SSD-10365 St Francis College Stage 1 - Landscaping

Thank you for your correspondence via Major Projects Planning portal (ref: PAE-3795) on 30 June 2020, requesting Transport for NSW (TfNSW) to review the subject matter.

Safety of the Pick-up and Drop-off Arrangement

Figure 2.1: Proposed Car Parking Layout

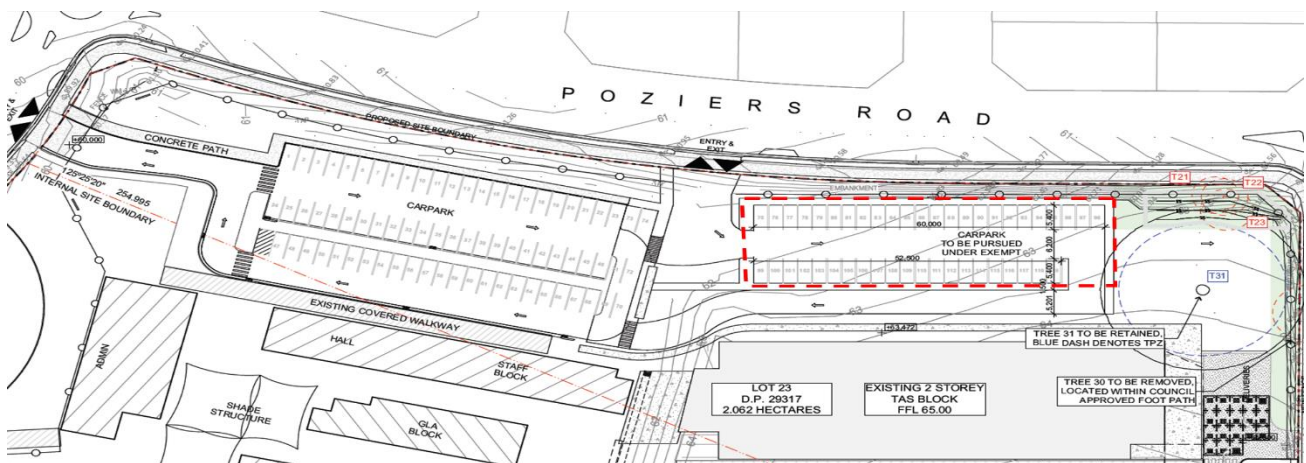
It is noted that a revised queuing assessment has been undertaken for the pick-up and drop-off arrangement as part of the development application. However, no safety assessment has been undertaken for the student movements between parked cars and reversing cars into parking spaces to access pick-up and drop-off area as 185m long pick-up and drop-off area within the car park extends beyond the pick-up and drop-off bay.

It is requested that the applicant be conditioned to undertake a Road Safety Audit for the school pick-up and drop off areas, prior to the issue of the construction certificate, in accordance with *Austroads Guide to Road Safety Part 6: Managing Road Safety Audits* and *Austroads Guide to Road Safety Part 6A: Implementing Road Safety Audits* by an independent TfNSW accredited road safety auditor. Based on the results of the road safety audit, the applicant shall implement safety measures, if required.
